Subject: app3/2016/0011 Curtis House Chipping Road Longridge

Highways Development Control

Lancashire County Council

Drawing Title
PROPOSED SITE PLAN

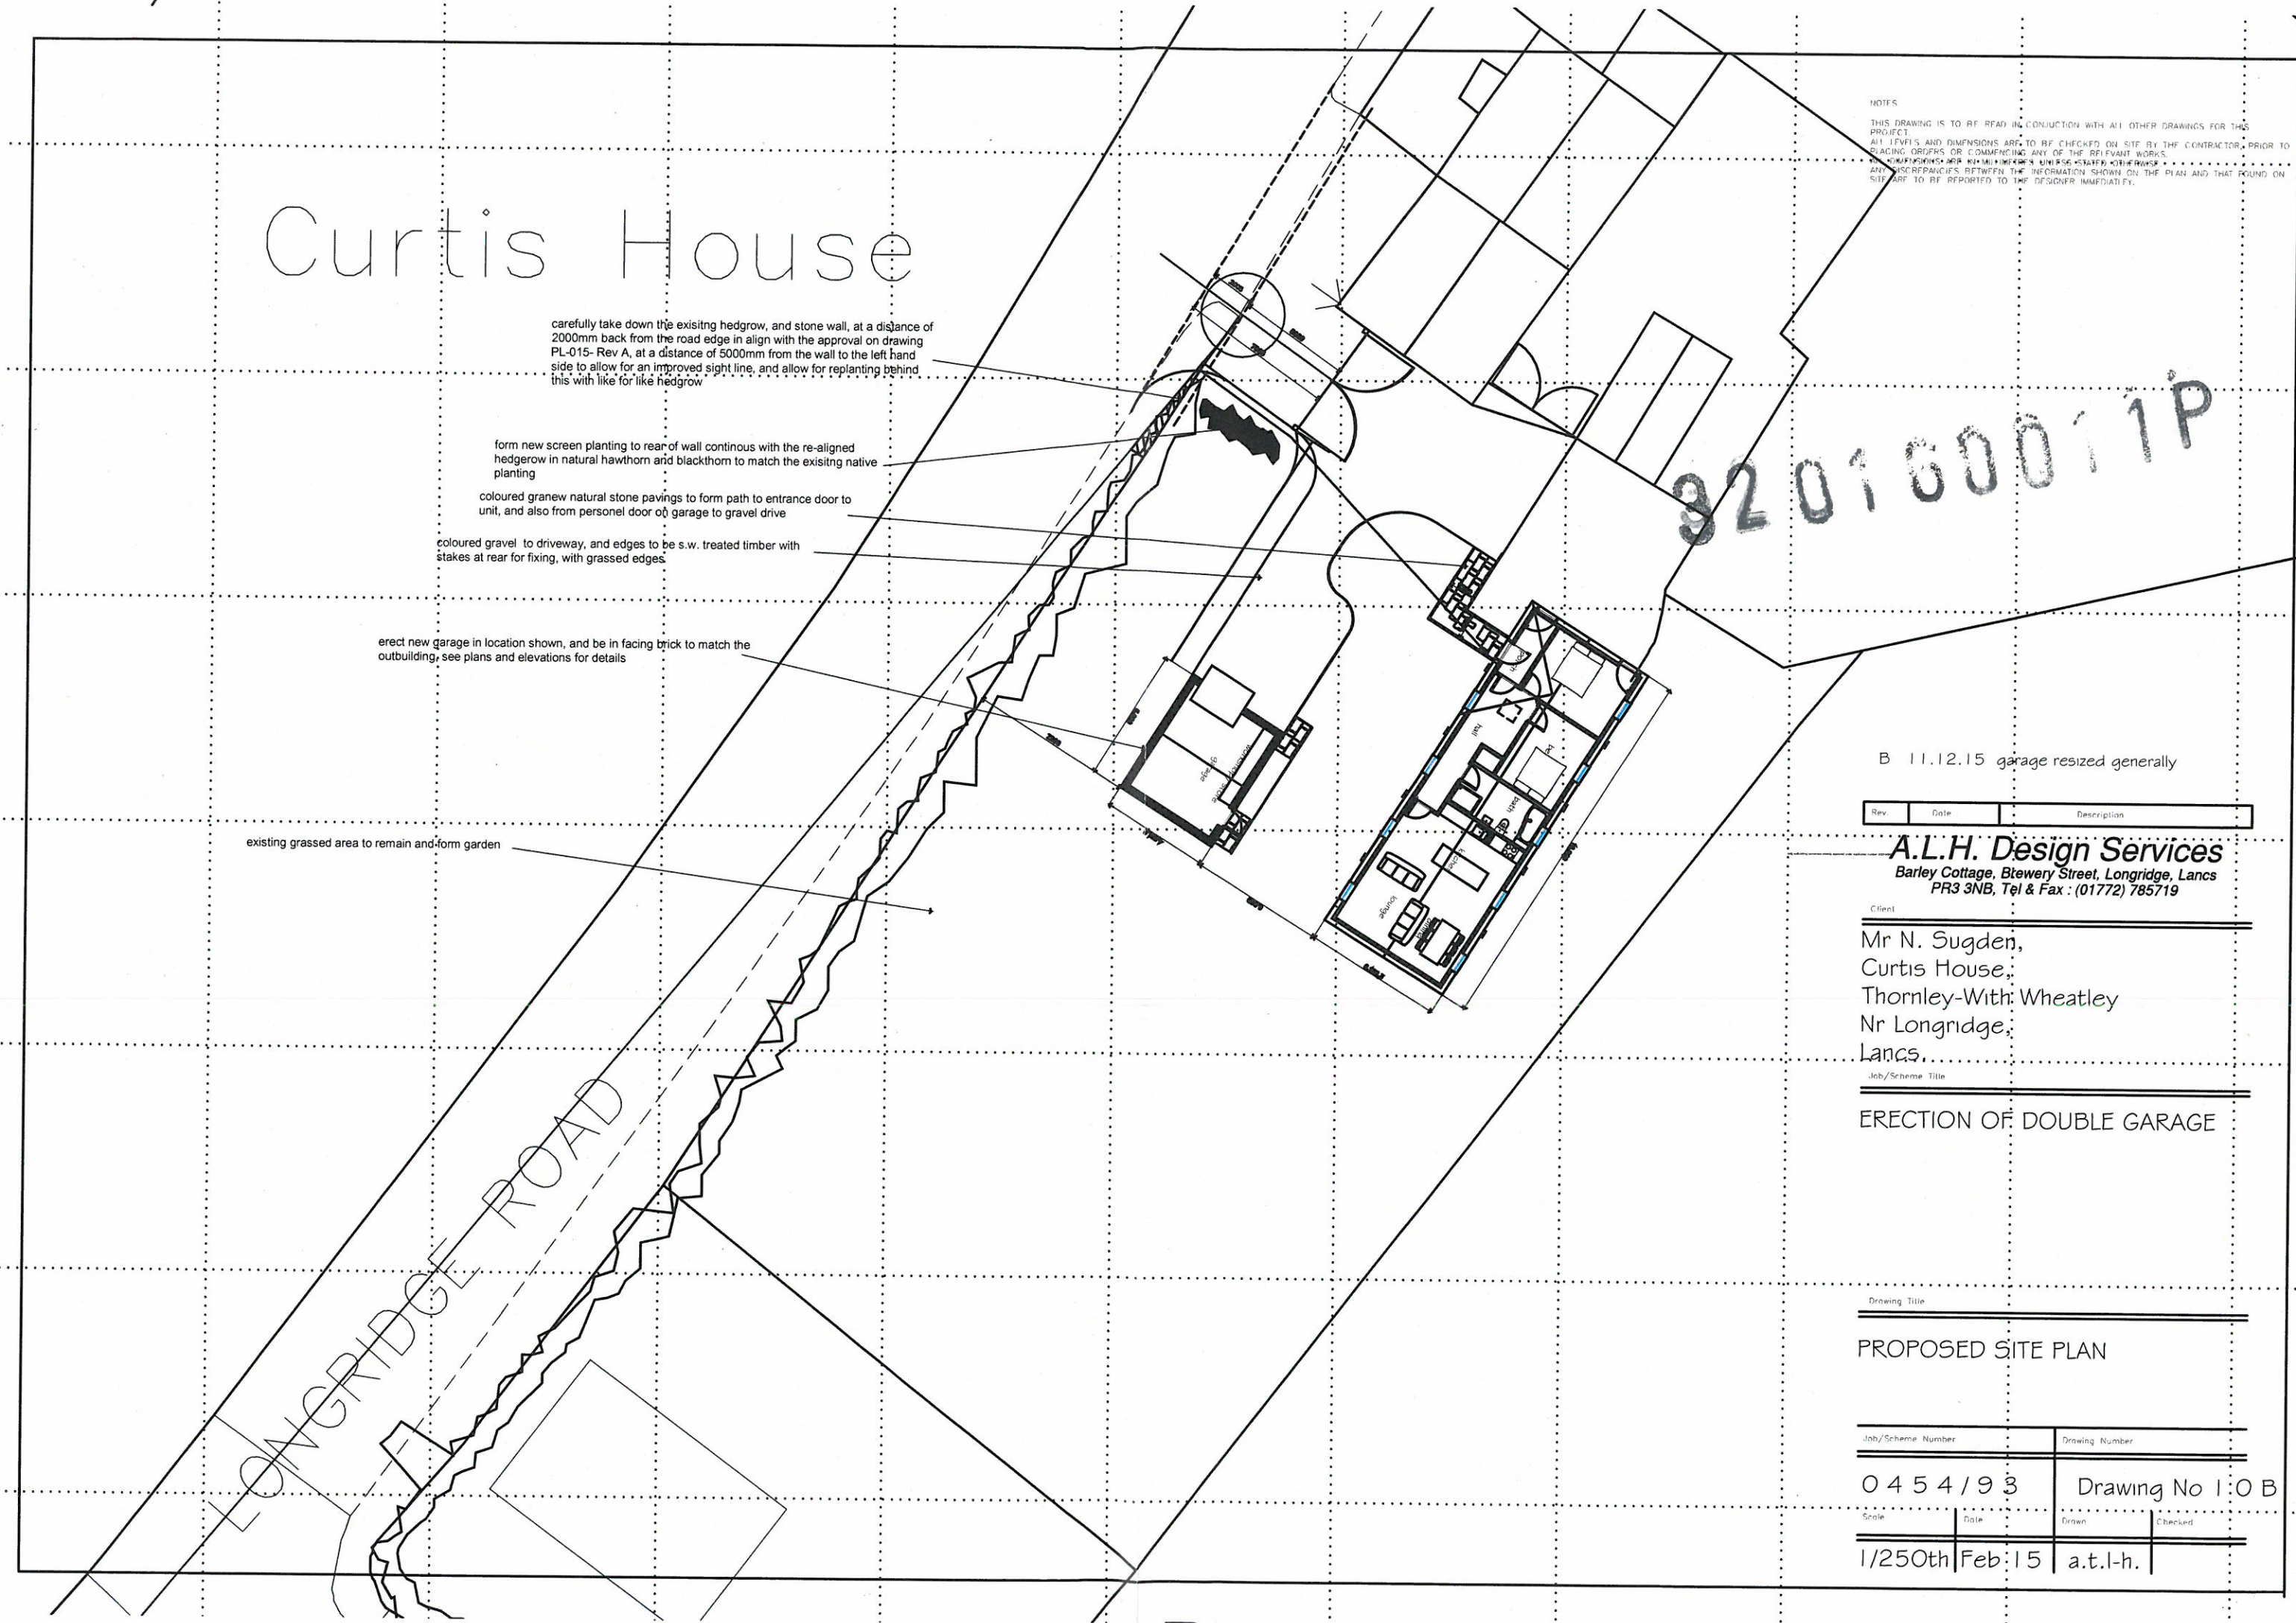
This application is similar to application 3/2015/0272 to which I raised no objection subject to the access being as shown in a previous application (3/2014/0425) copy attached. In the appeal decision for the 2015 application the appeal inspector referred to the anomaly between the submitted plan and the approved plan but suggested that the discrepancy could be overcome by means of a planning condition, therefore subject to the following condition being attached to any permission that may be granted I would raise no objection to the proposal on highway grounds.

1 No part of the development hereby approved shall commence until a scheme for the construction of the site access and the off-site works of highway improvement has been submitted to, and approved by, the Local Planning Authority in consultation with the Highway Authority. Reason: In order to satisfy the Local Planning Authority and Highway Authority that the final details of the highway scheme/works are acceptable before work commences on site
